**City of Colorado Springs-Tutt Road and Cottonwood Drainage Project,**  
**EX-19-001,(REVISED)**

Please accept the following comments from El Paso County Public Health for the project referenced above:

Mike McCarthy, R.E.H.S.  
Environmental Health Division  
El Paso County Public Health  
719.575.8602  
[mikemccarthy@elpasoco.com](mailto:mikemccarthy@elpasoco.com)  
02Apr2019 (REVISED)

SHEET 2 OF 2 FILE: 17023L.SP.DWG 03/26/19 JLB

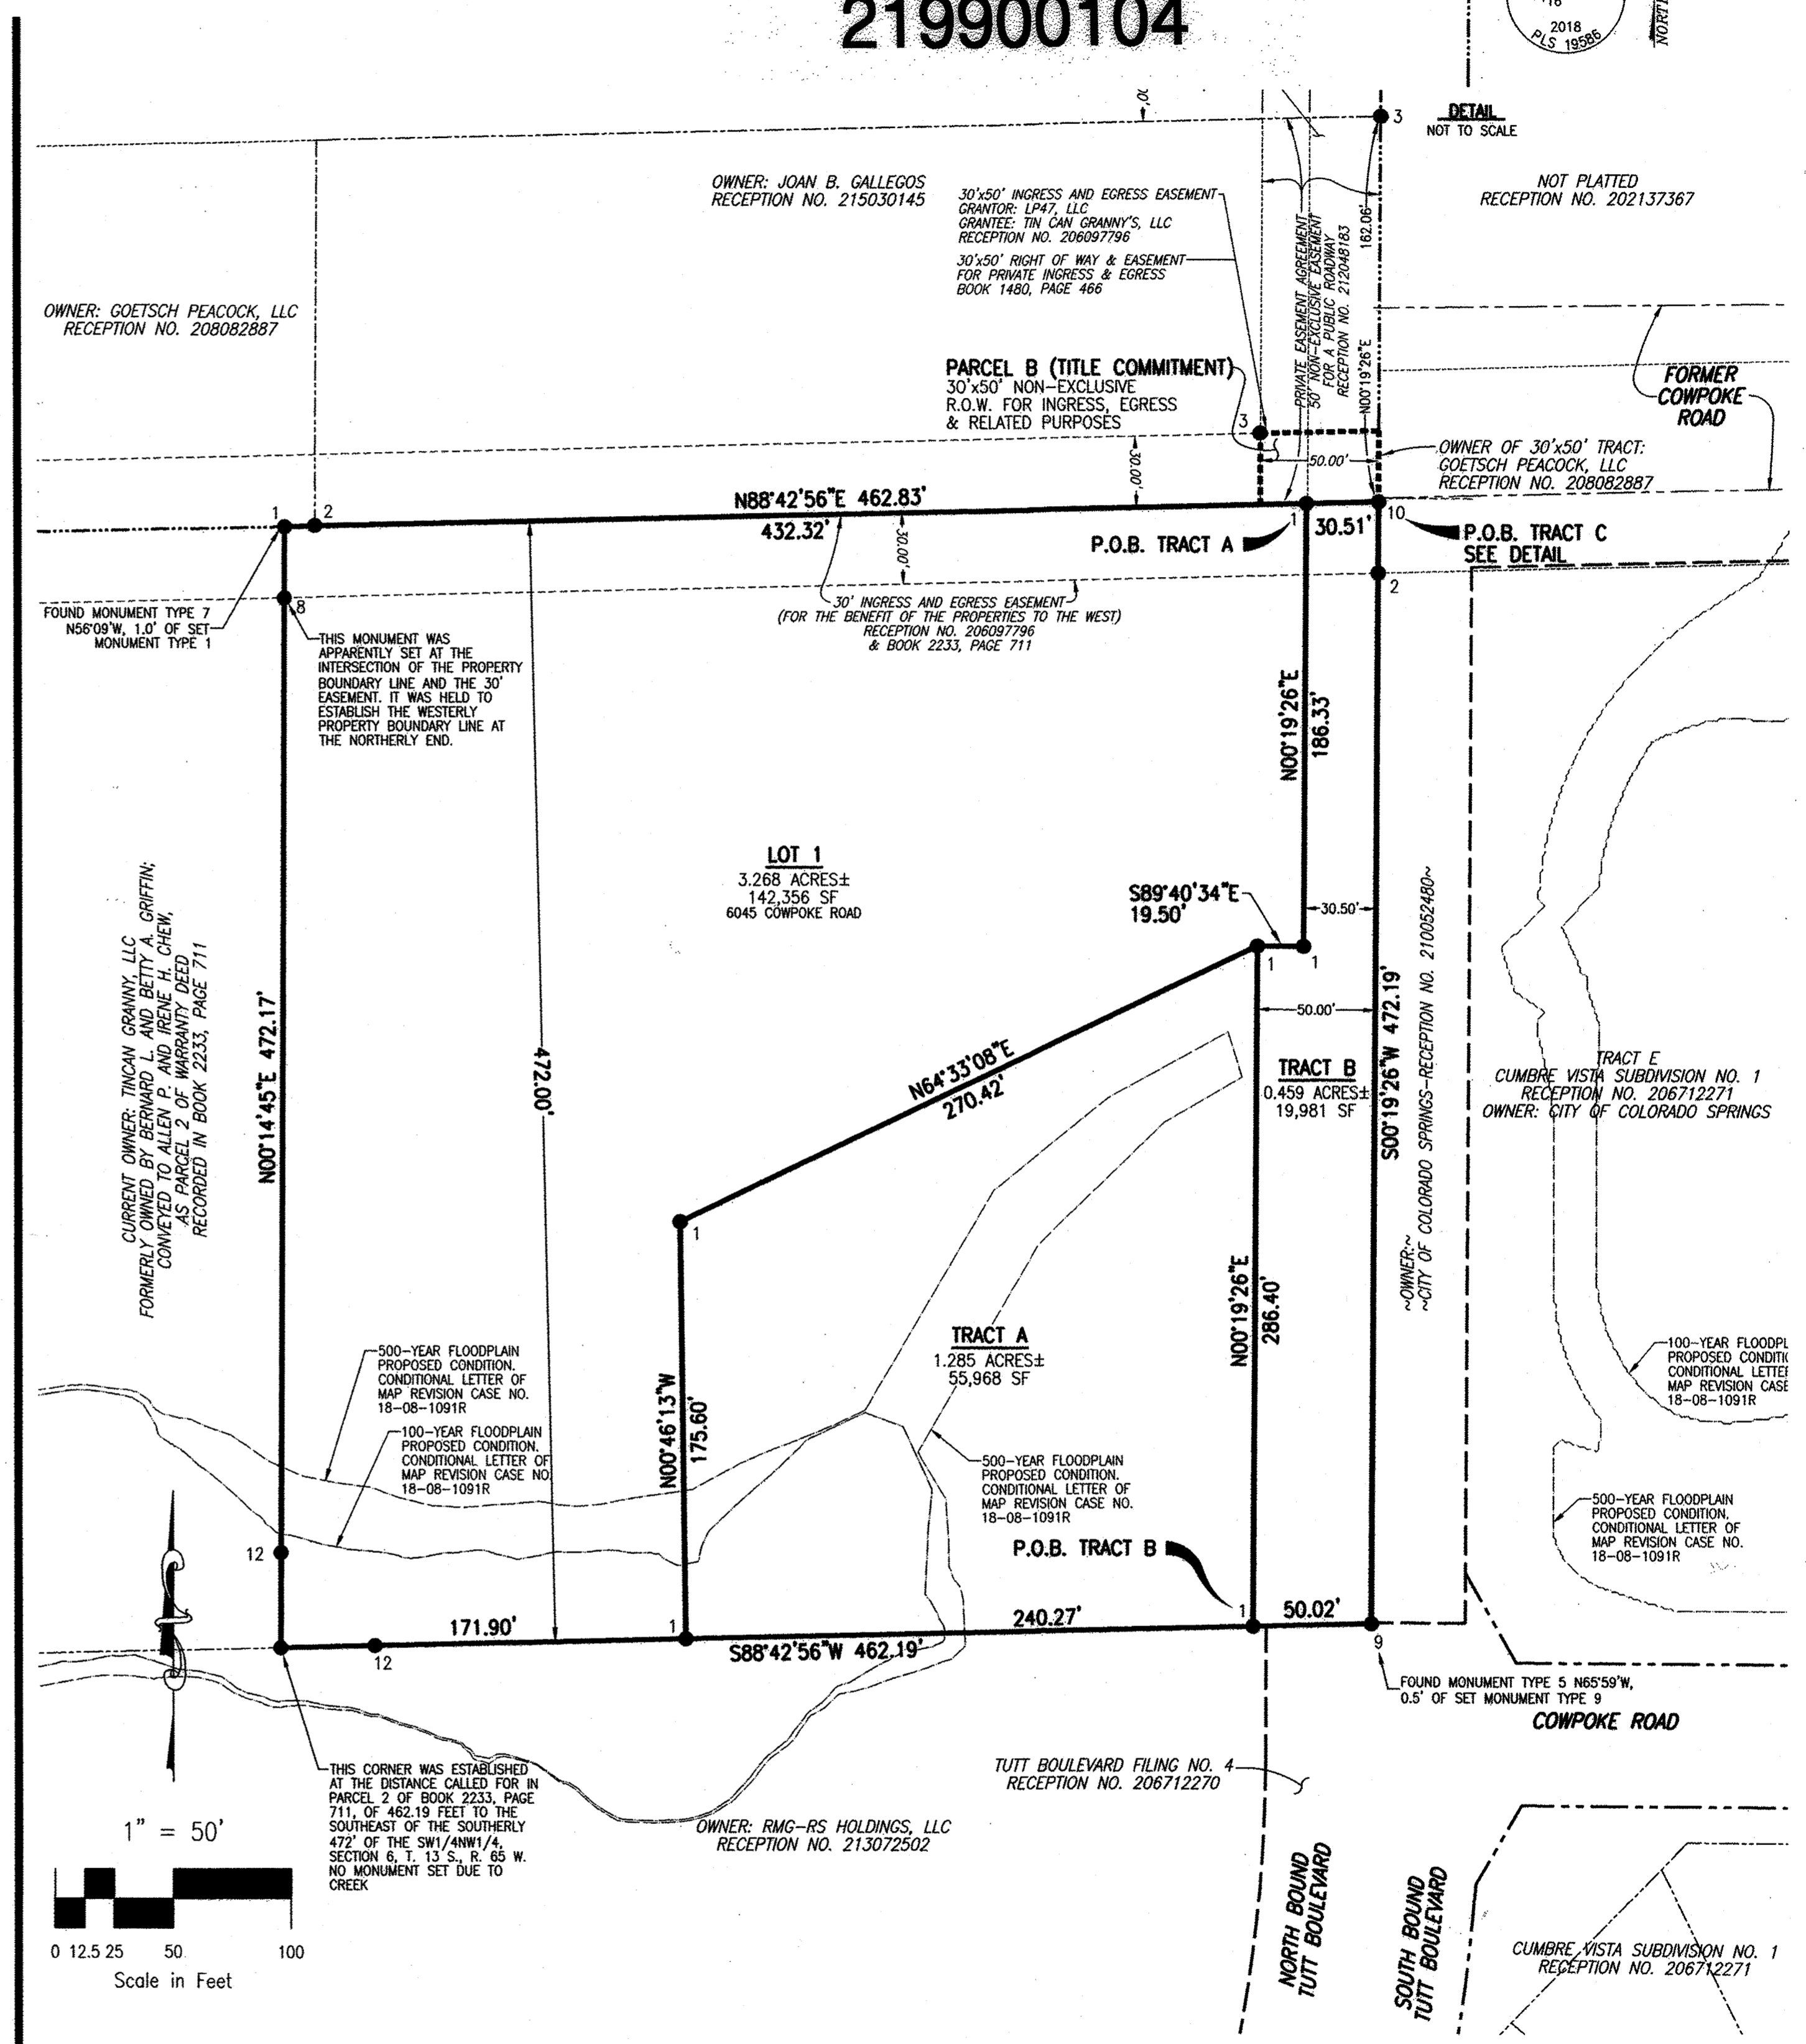
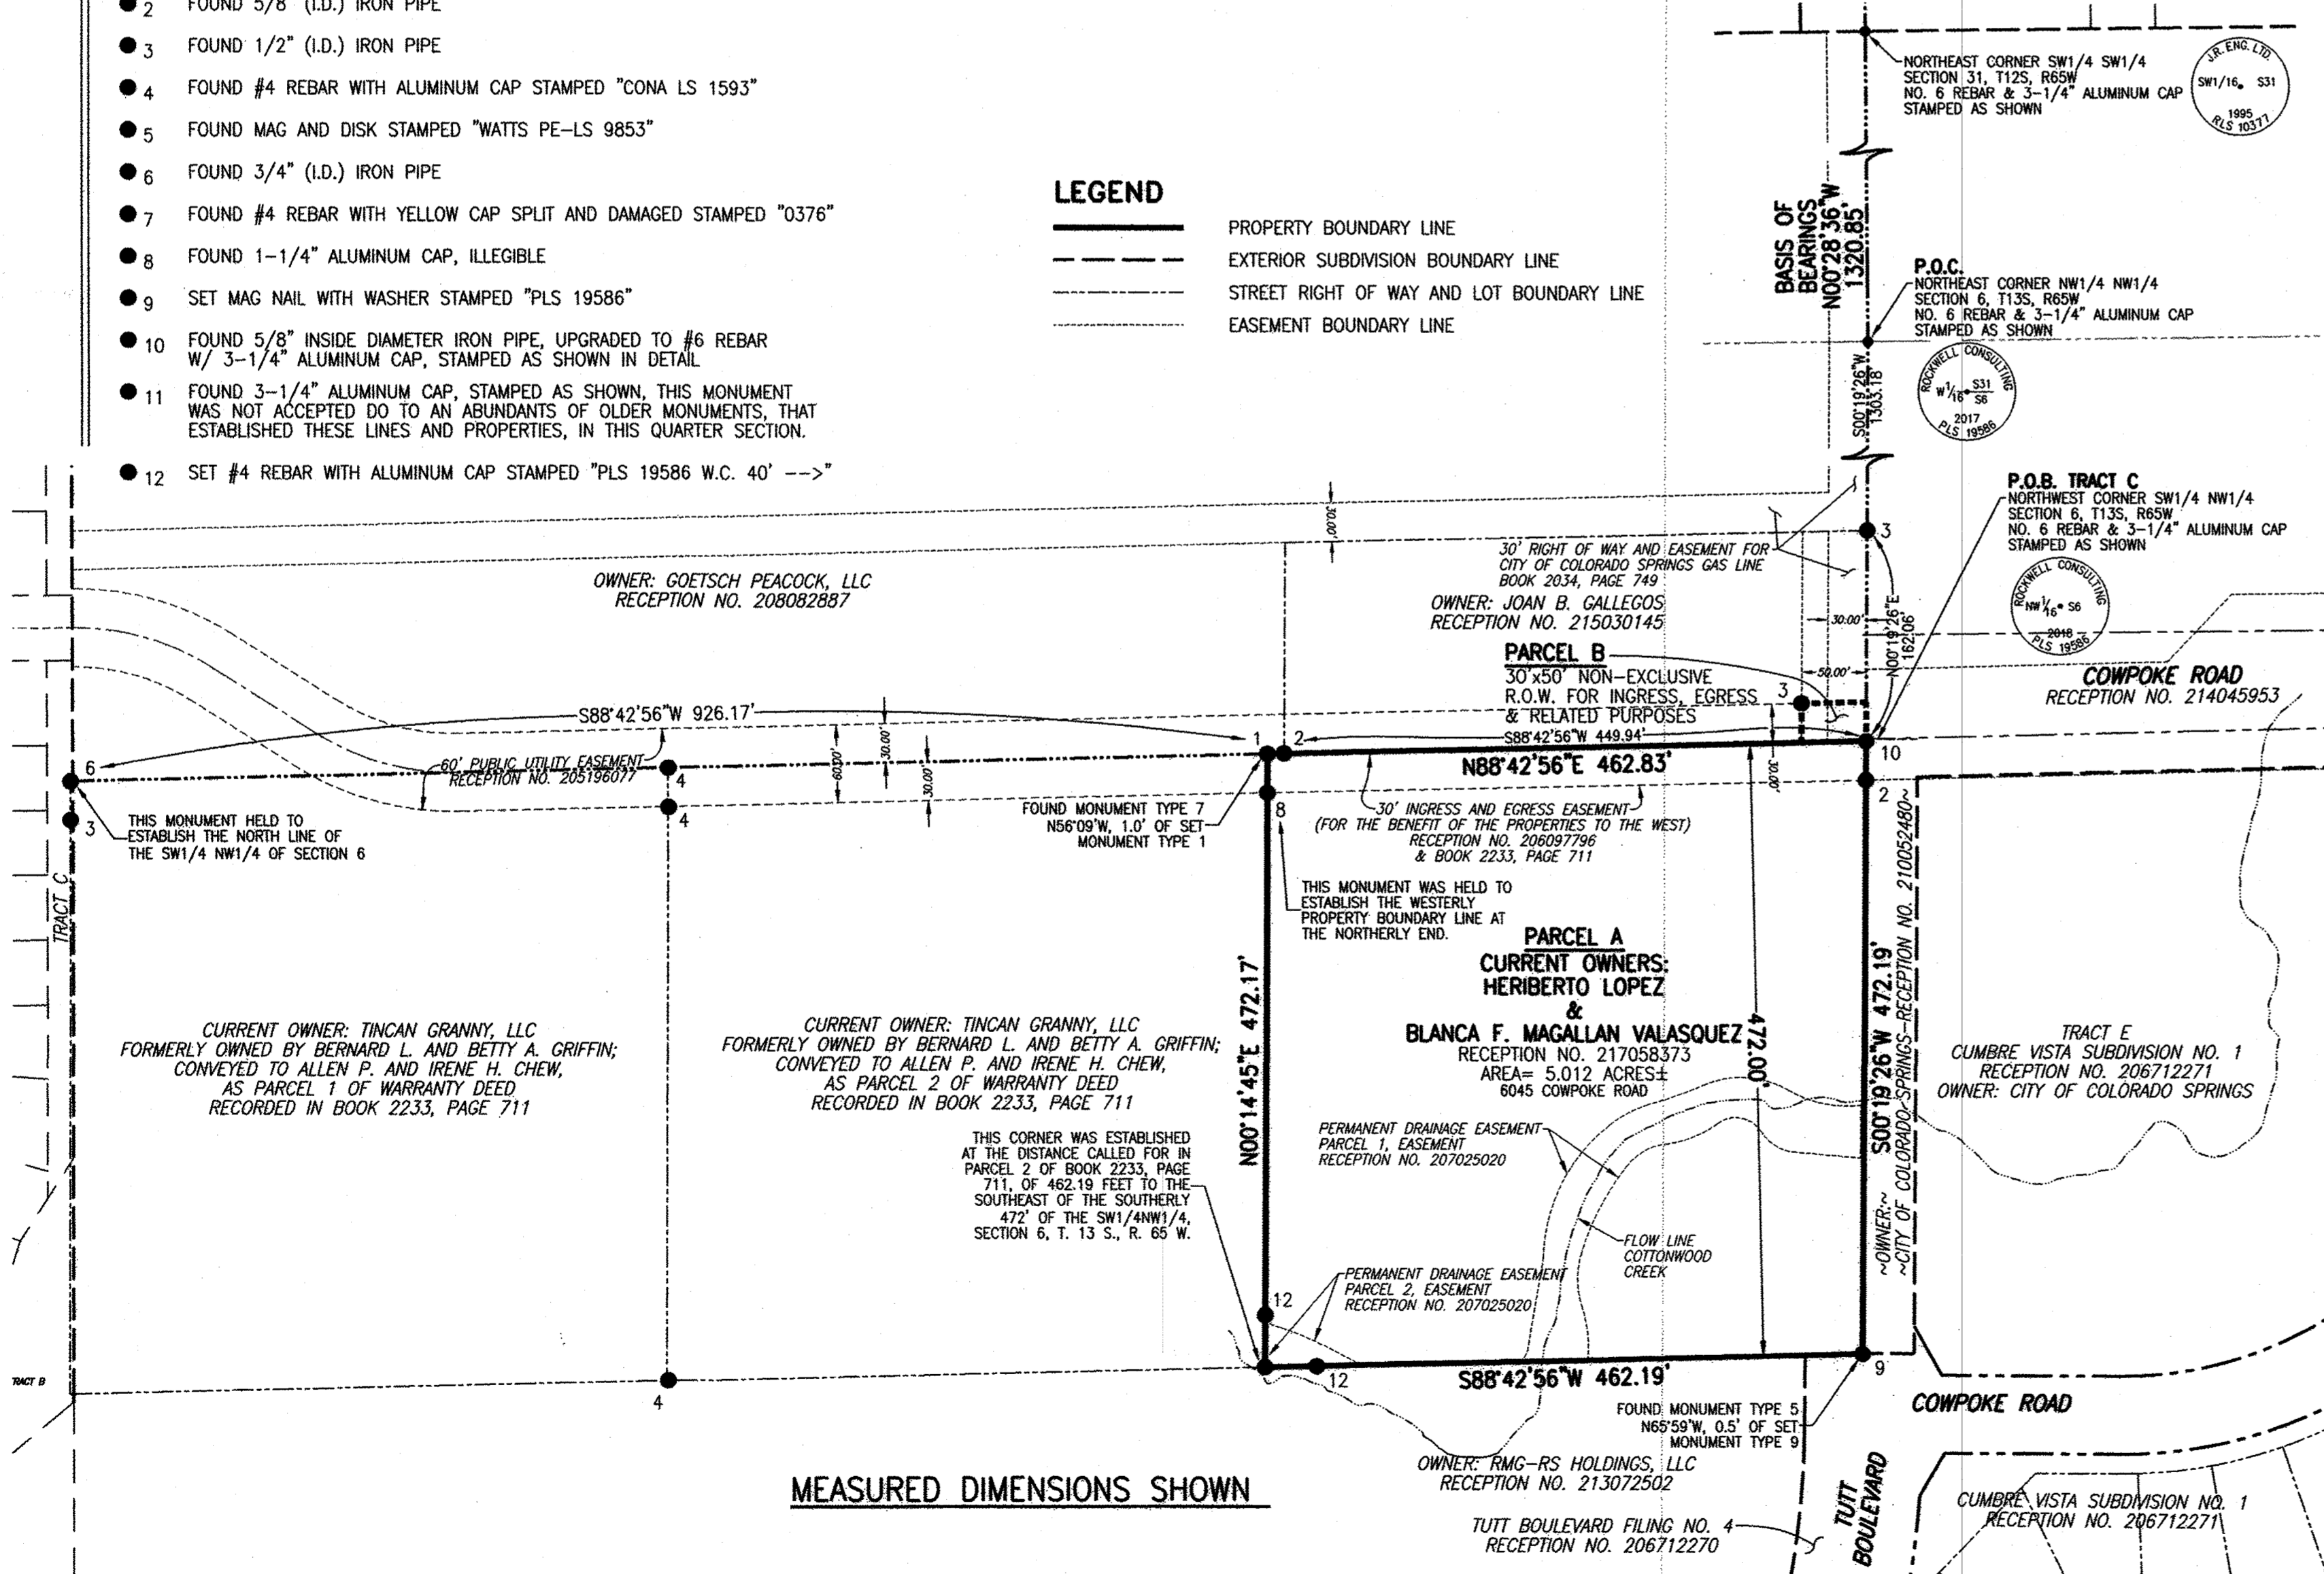
- **The existing onsite wastewater treatment system (OWTS) must be entirely located on the remaining 3+ acres and meet all minimum horizontal installation setbacks found in the El Paso County Board of Health, Chapter 8, Onsite Wastewater Treatment System Regulations. This includes the location of the well. The following is required by El Paso County Public Health for verification of the OWTS components:**

- **All components (septic tank, distribution box, and the two trenches) of the OWTS must be located and marked on the property by an OWTS Certified Inspector or Licensed OWTS Contractor. Locator paint is recommended for use.**

- **The proposed new property line must be accurately marked in the vicinity of the OWTS components.**
- **A drawing with accurate measurements of all the OWTS components to the proposed new property line must be submitted to El Paso County Public Health prior to approval of this request. Also include measurements of the septic tank and the closest part of a STA trench to the edge of the creek embankment.**
